Application No: K/17/22/PL
Site Address: Panorama Golden Acre Kingston BN16 1QP
Description of works: Conversion of existing 2 No flats into 1 No dwelling, single-storey extension with a sloping roof, new porch on ground floor, conservatory at first floor and roof extension, replacement of existing windows, doors and roof tiles. This site is in CIL Zone 4 and is CIL Liable as new dwelling.

Thank you for your internet representation made on 7th July 2022 which has been recorded as no objection with the comments as follows:

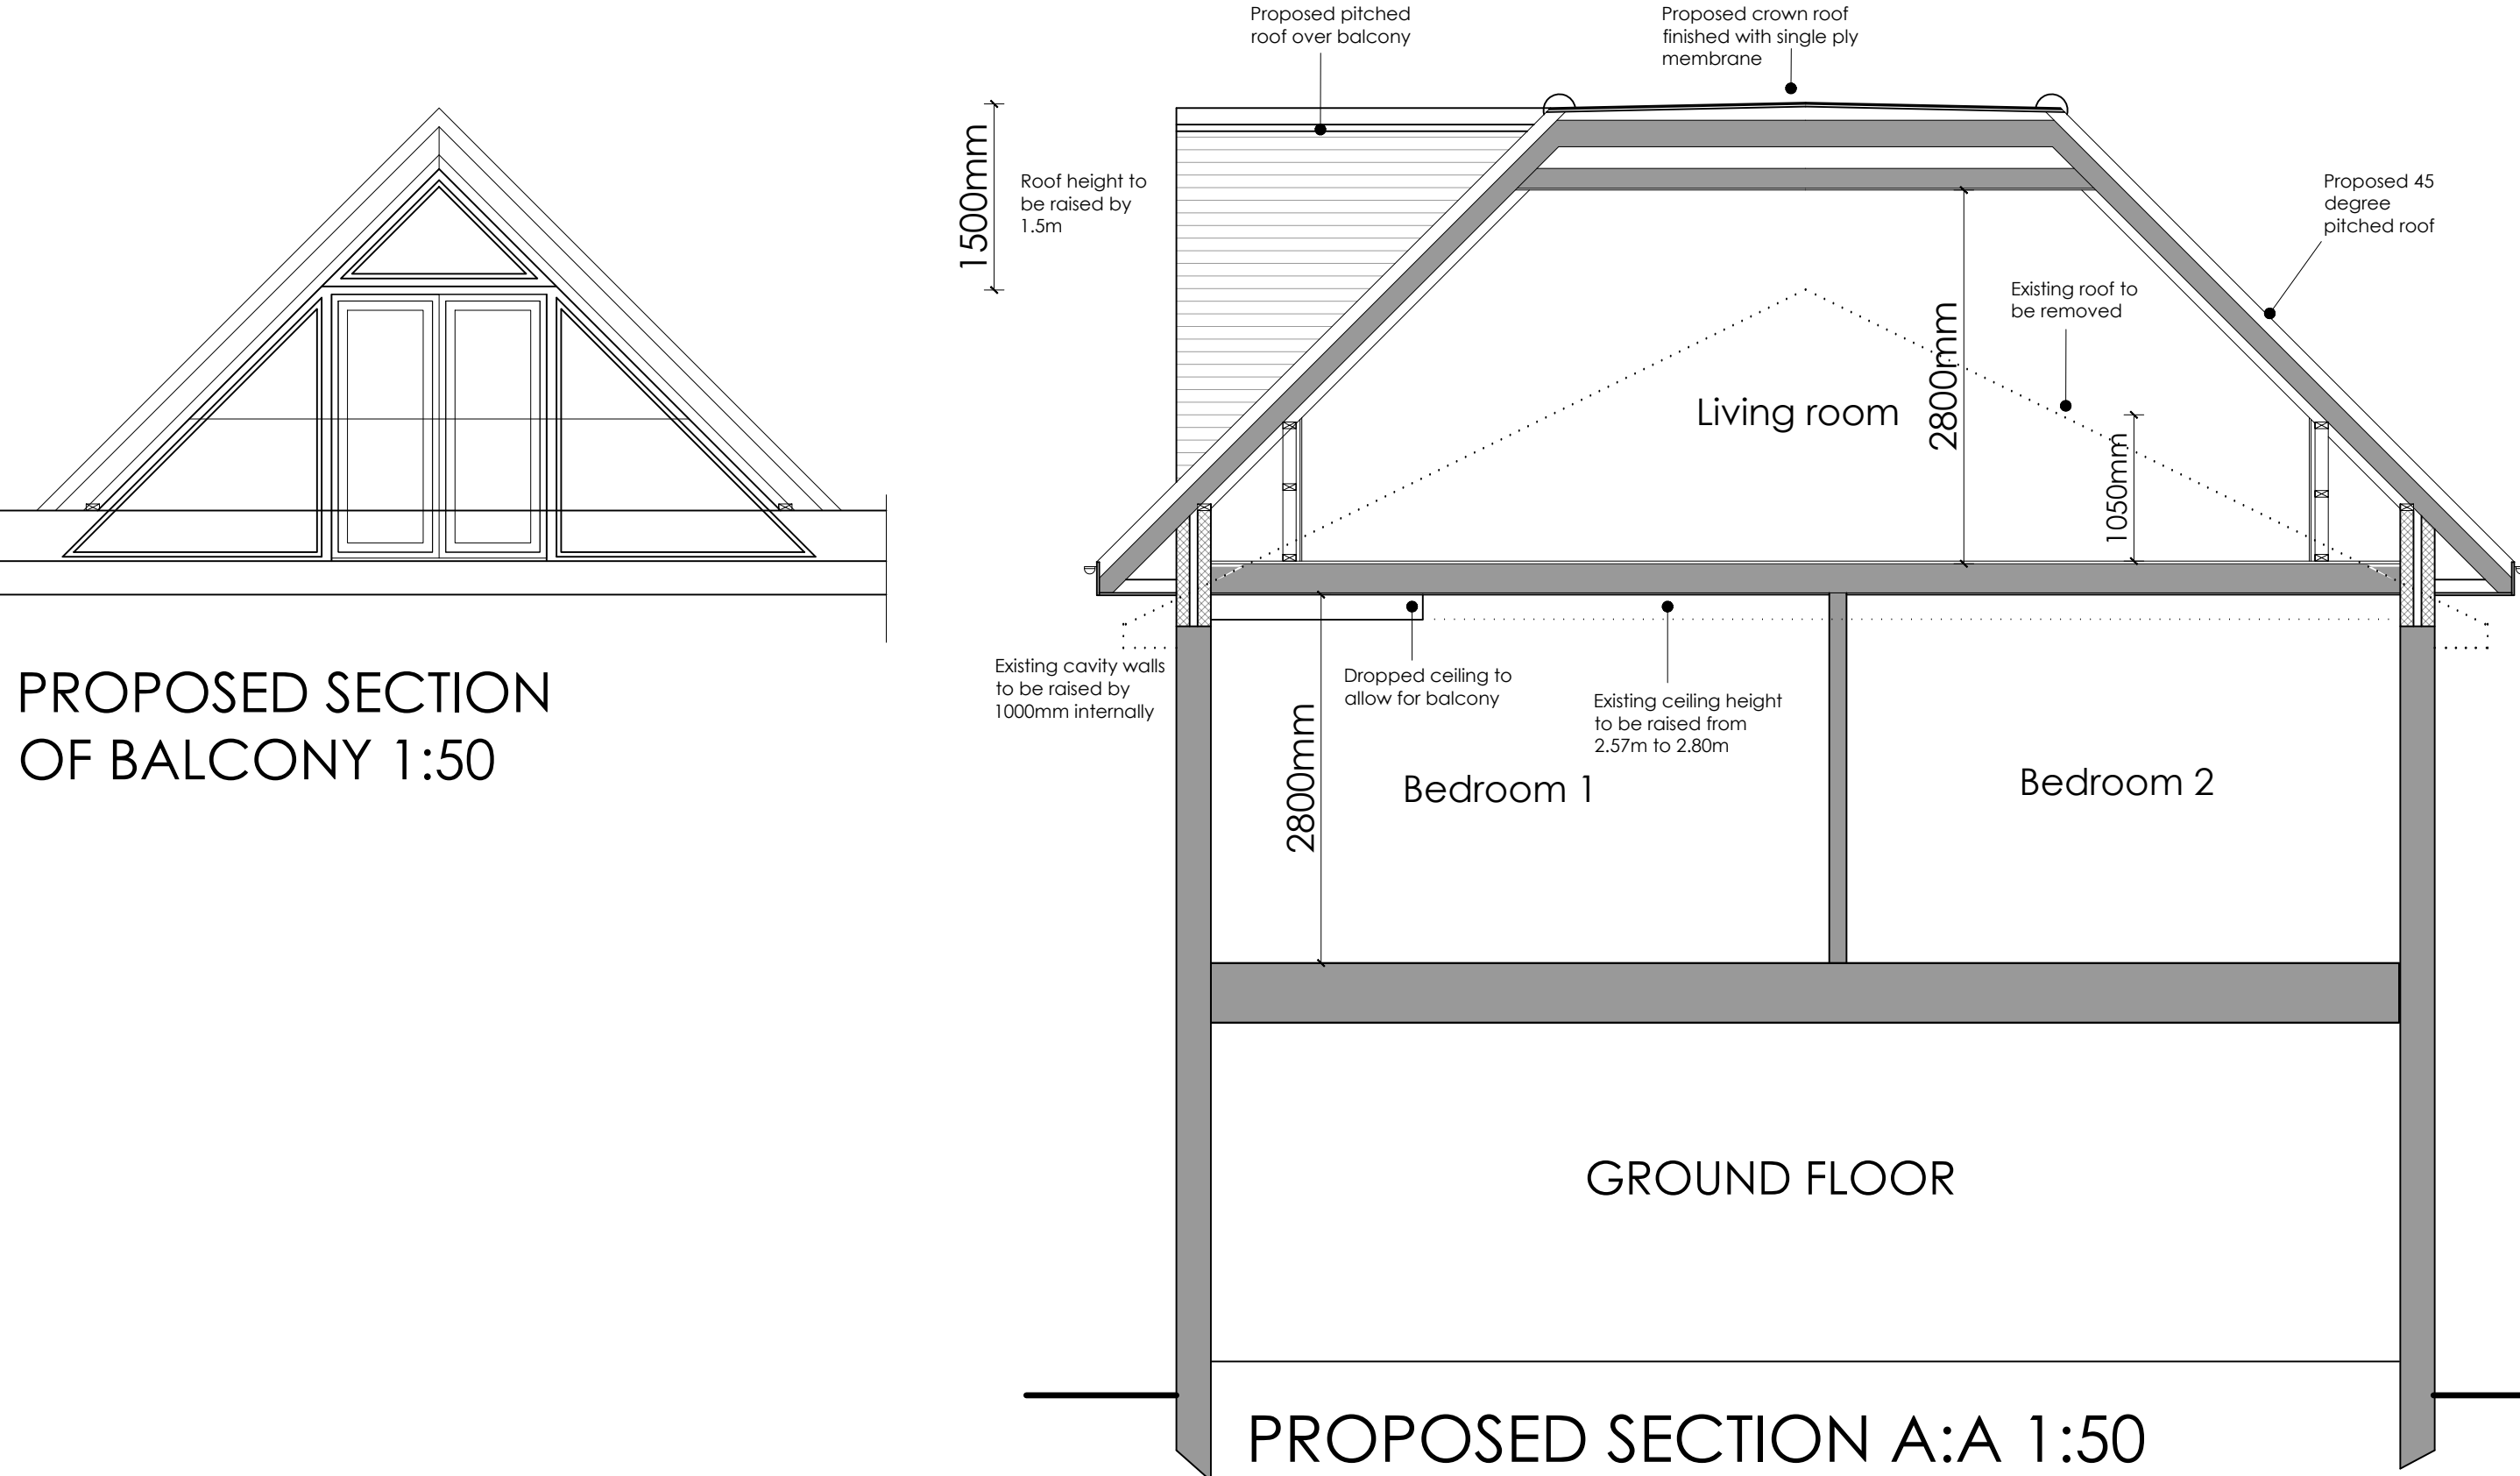
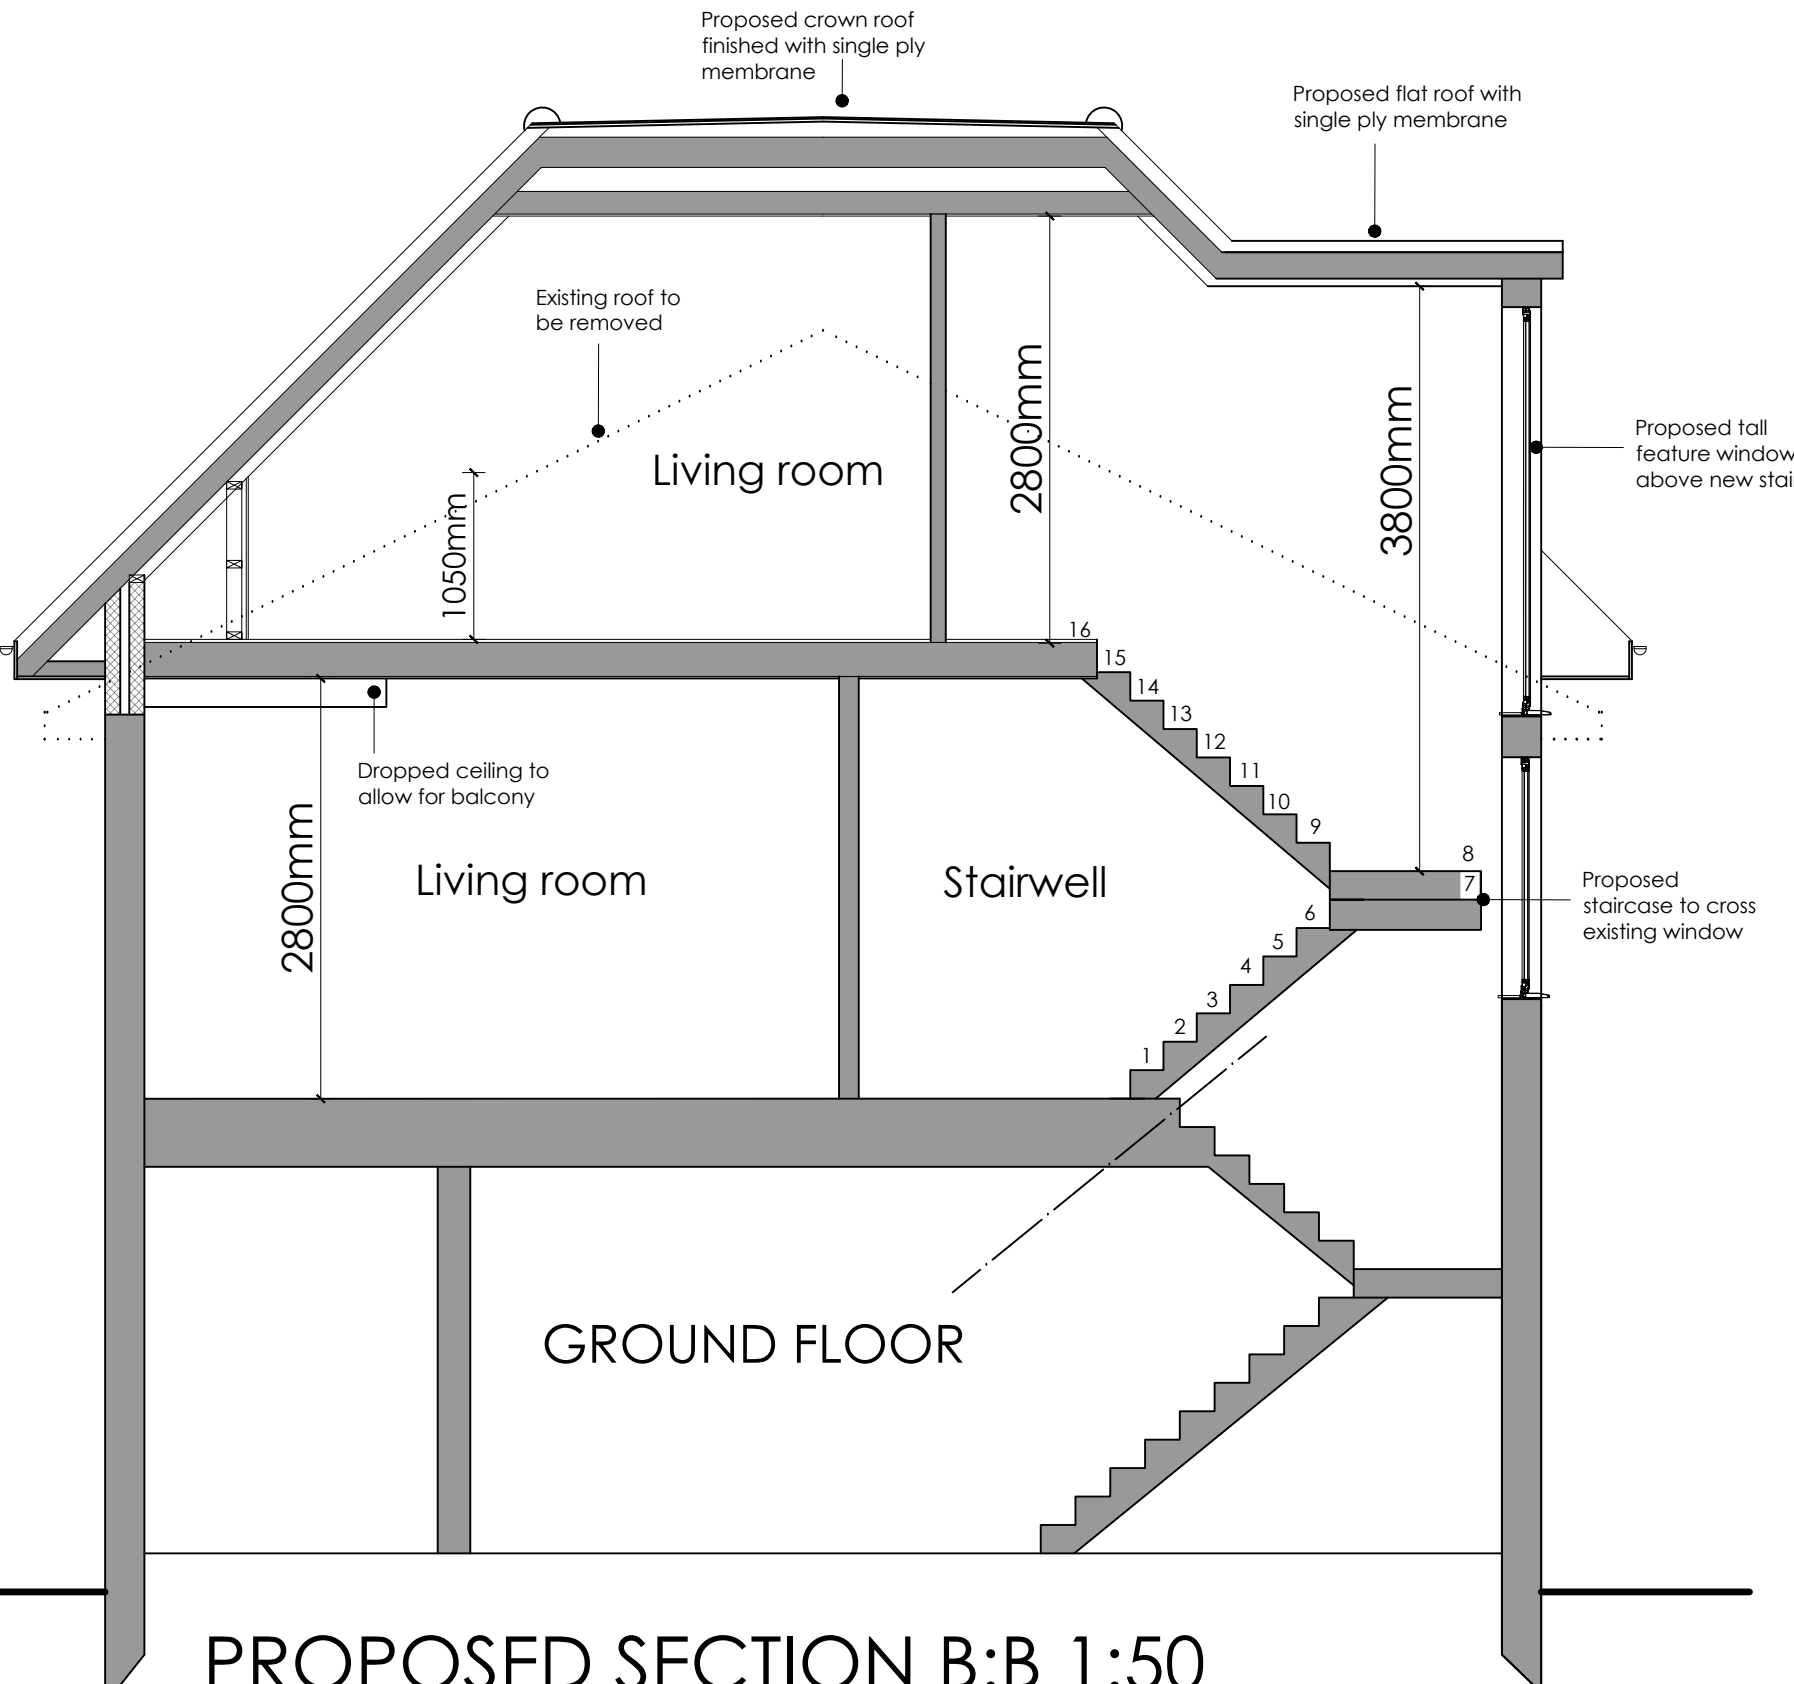
Council has no objection subject to the condition relating to previous application K/40/20/HH I being repeated "Screening shall be constructed at a height of 1.7m from the roof terrace floor level, and extend along the entirety of the Eastern, and 1.5m of the Northern sides of the terrace.", and that the case officer is satisfied that any new windows included in this application do not affect the privacy of neighbouring properties.
